POWERHOUSE PARRAMATTA
**DESIGN
INTEGRITY
REPORT**

Museum of
Applied Arts
& Sciences

This report outlines the design integrity process and review that has occurred to support a modification application for Powerhouse Parramatta SSD-10416 for amendment of the pavilion roof and fit out and use of St George's Terrace.

1  
1 : 100  
PROPOSED PLAN - GROUND FLOOR

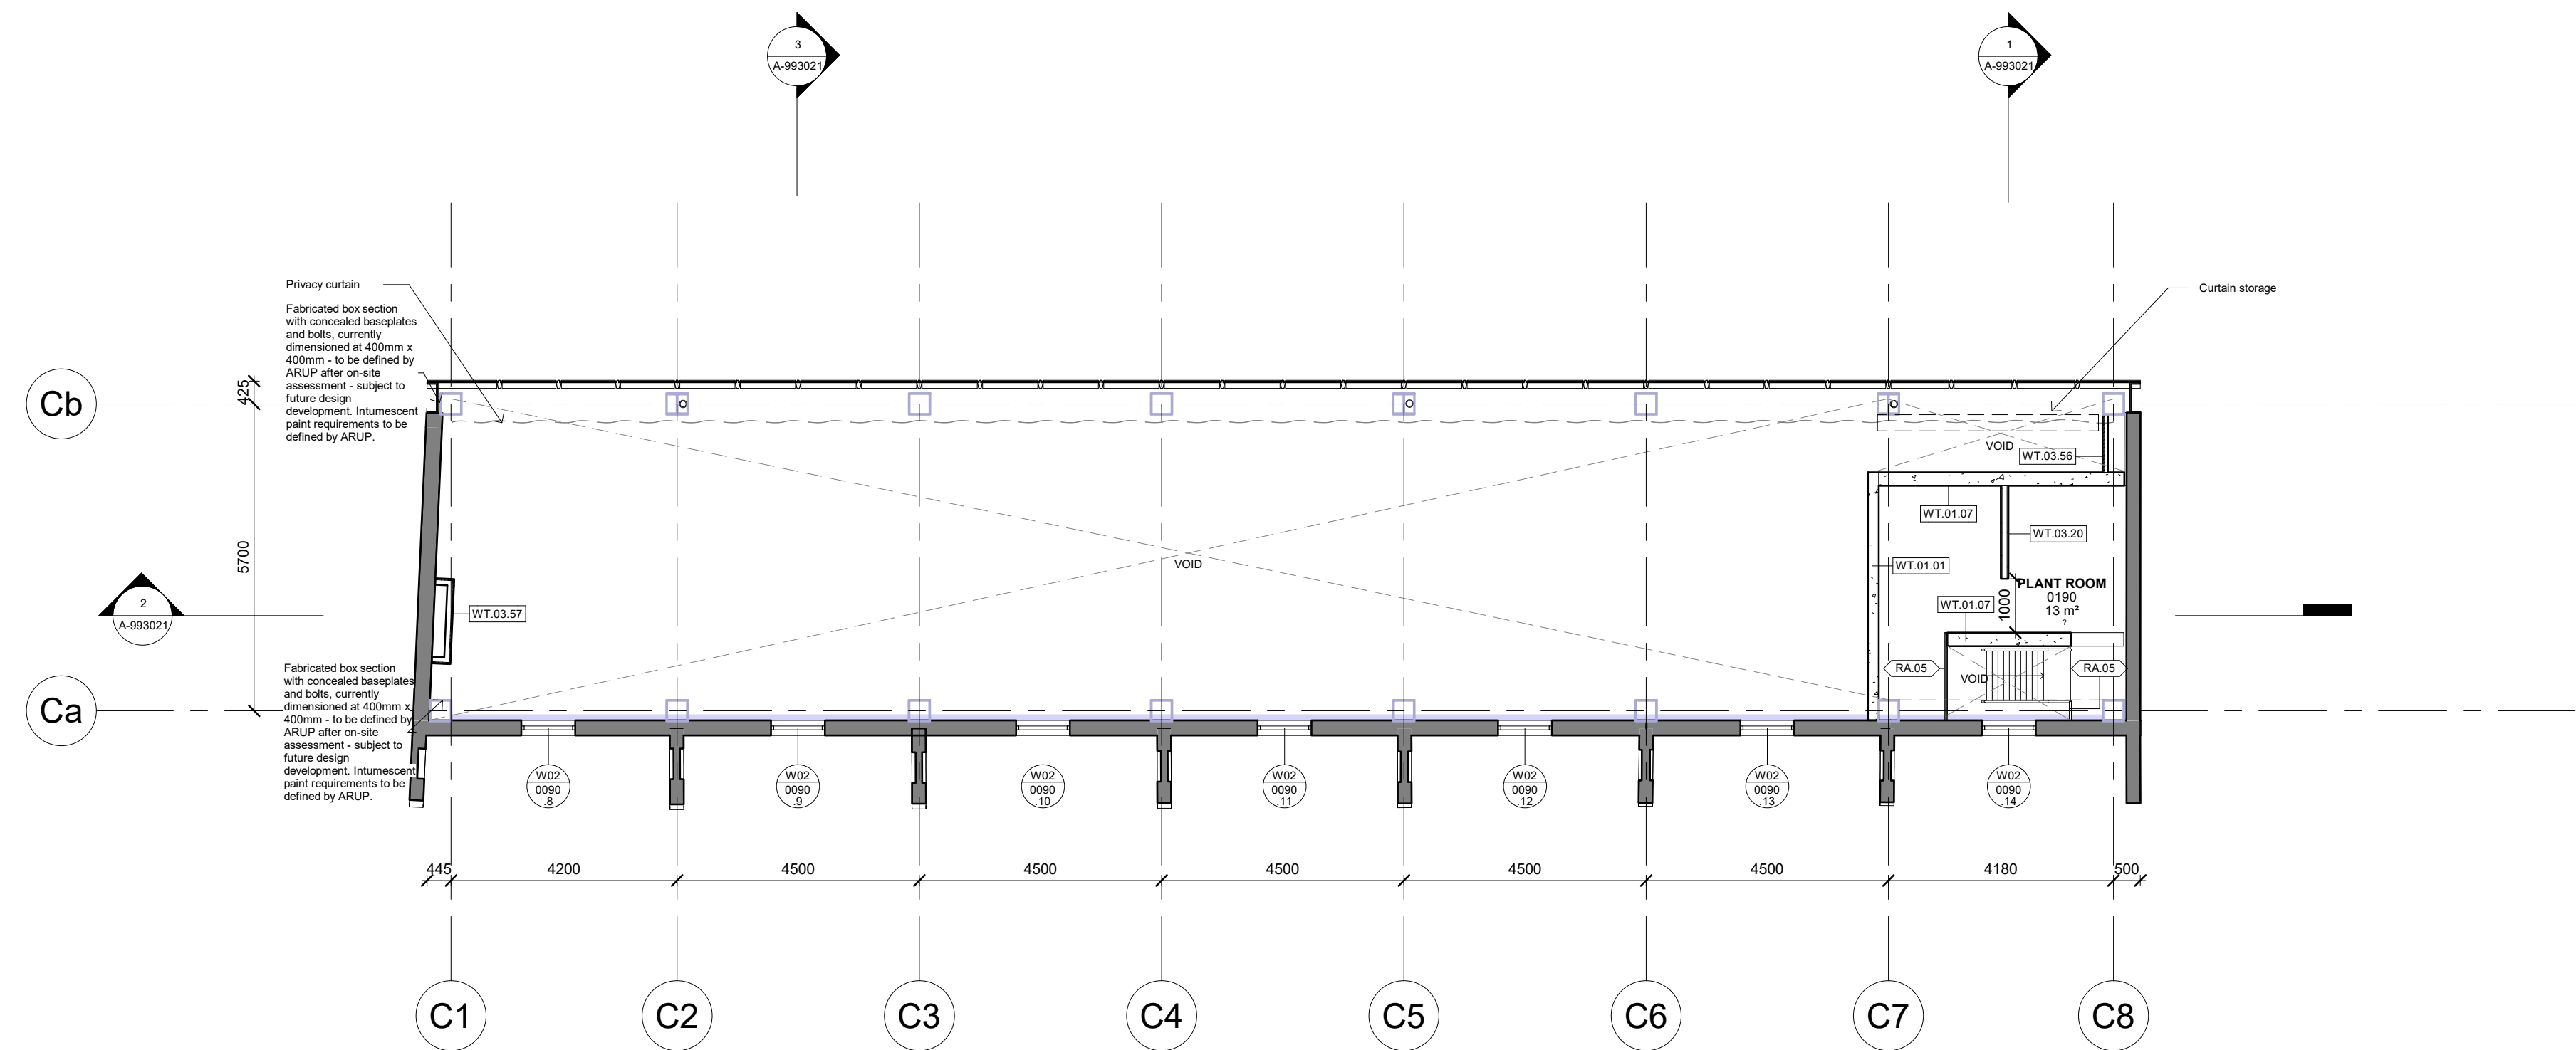
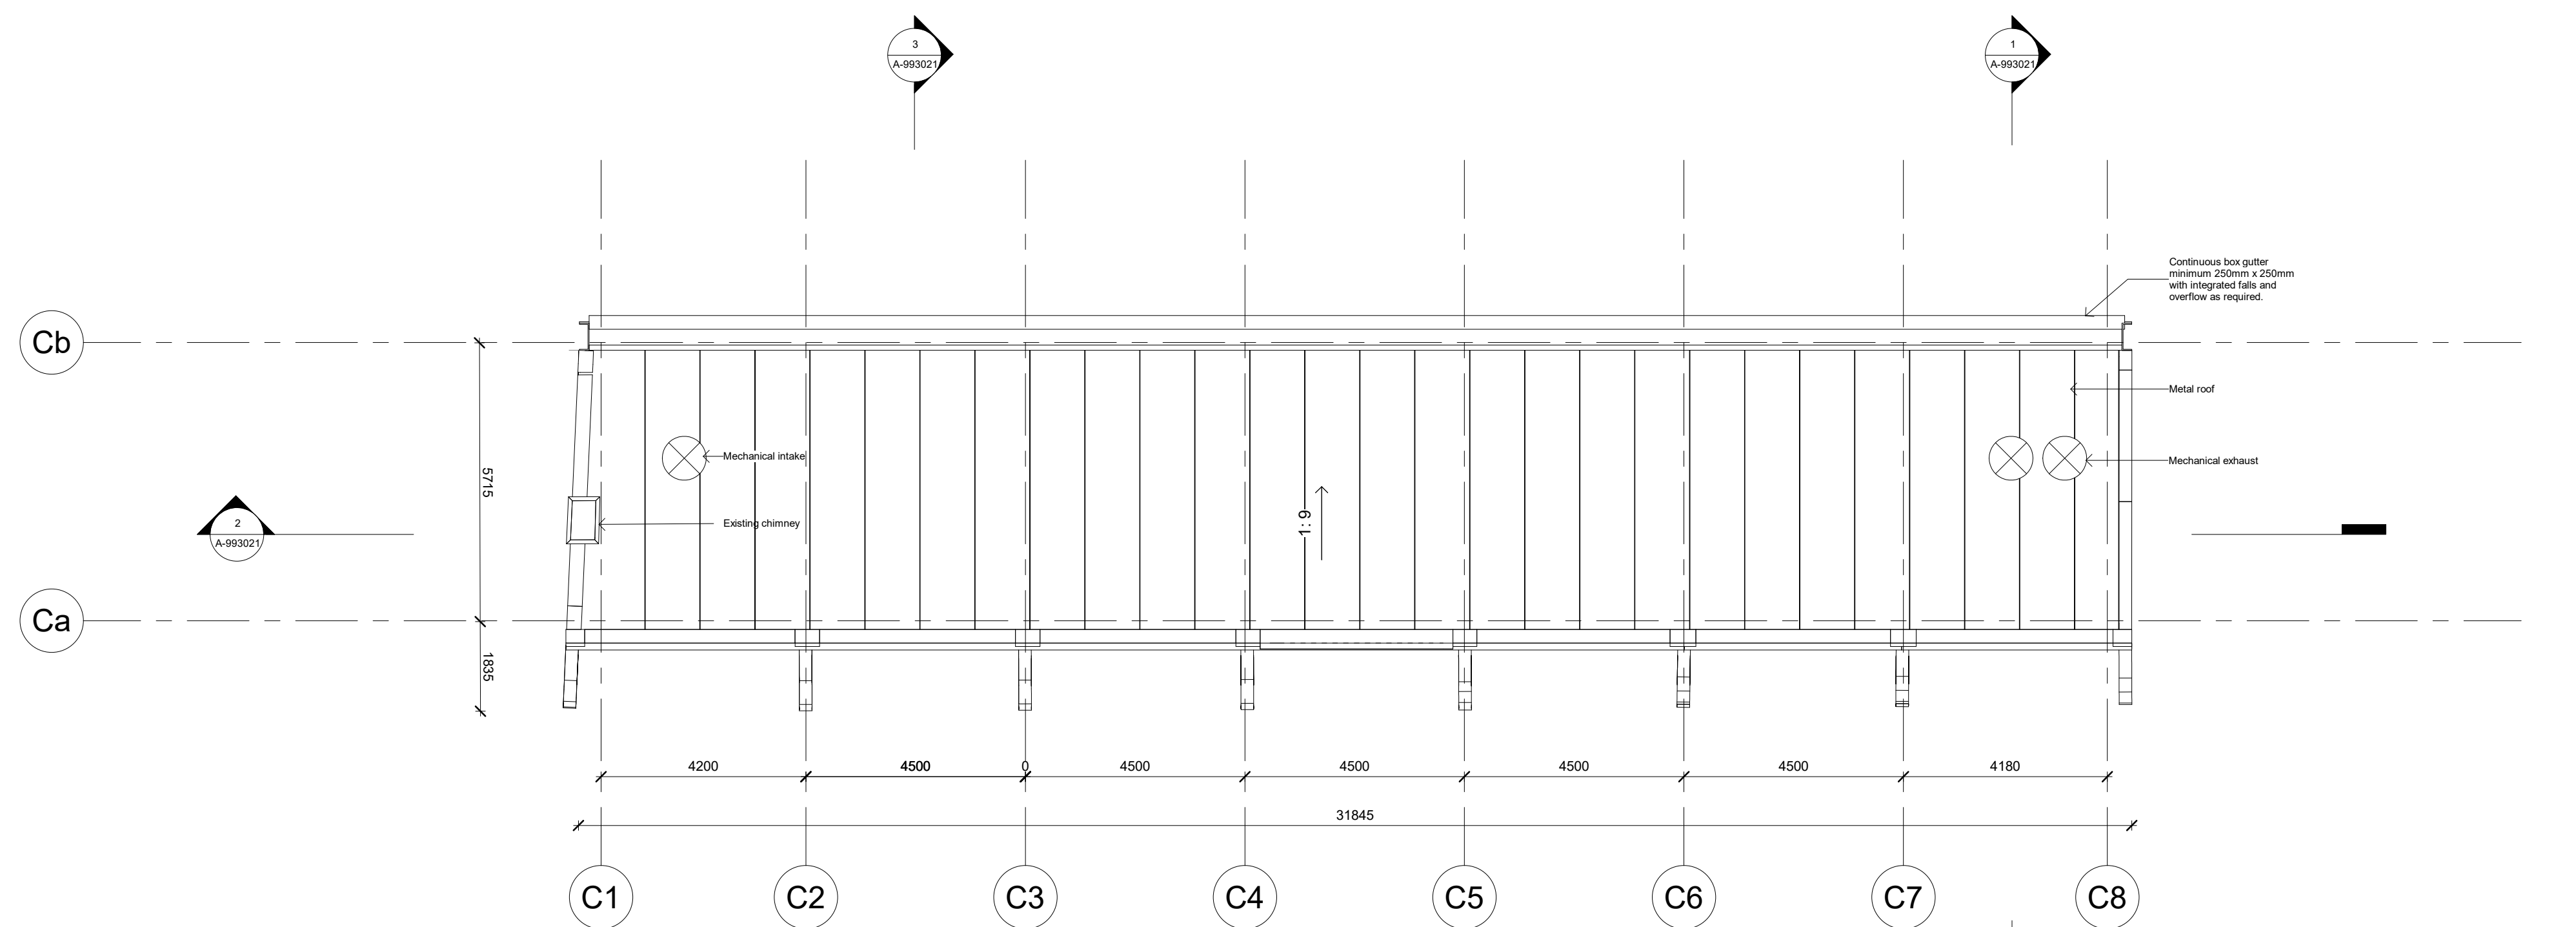
The proposal to transform the terrace to a flexible, double height space is considered in-keeping with the ethos of the remainder of the Powerhouse Parramatta design. A minimal design palette mirrors the eastern and western museum buildings and creates a functional adaptive reuse of the heritage structure.

The Panel note that the structural steel support will interpret the original terrace party wall lines and a glazed and operable northern façade will create activation between the terrace and PS1. Further the replacement of existing (non-heritage) doors and windows along Phillip Street with fixed glazing will activate the streetscape with views into the museum activities hosted within.
